**REQUEST**

Current Zoning: ML-1 (manufacturing and logistics-1)  
Proposed Zoning: ML-1(CD) (manufacturing and logistics-1, conditional)

Approximately 17.31 acres located along the east side of Twin Lakes Parkway and north side of Interstate 485, south of Sam Roper Drive.

The petition proposes an automotive repair facility, auto dealership, warehouse and distribution center and all other commercial and industrial uses as permitted by right and under prescribed conditions and accessory uses, as allowed in the ML-1 zoning district.

Rezoning Plan
 Charlotte NC 28212

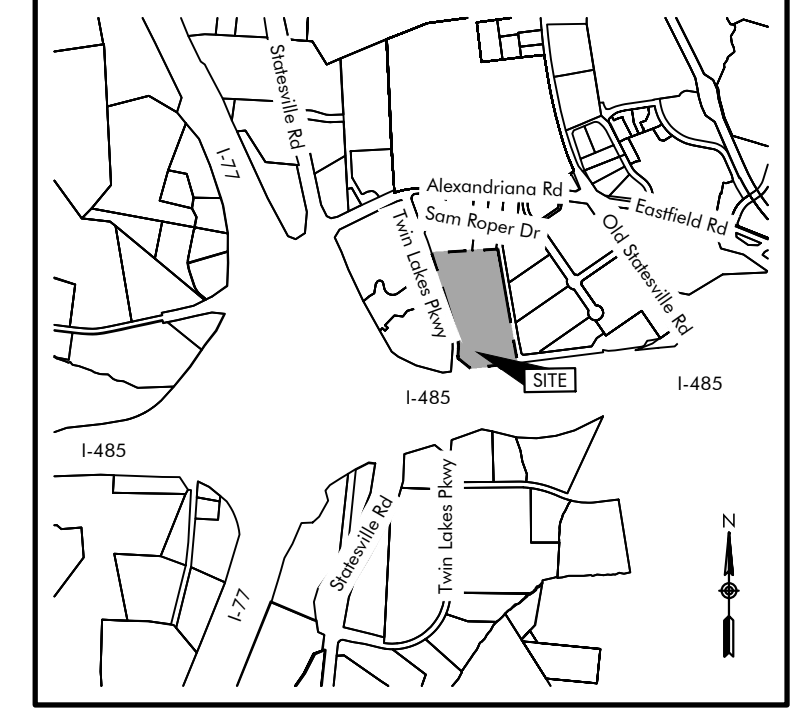
1. Density needed to determine potential CTR requirements. Additional comments or requirements may arise once density is provided.
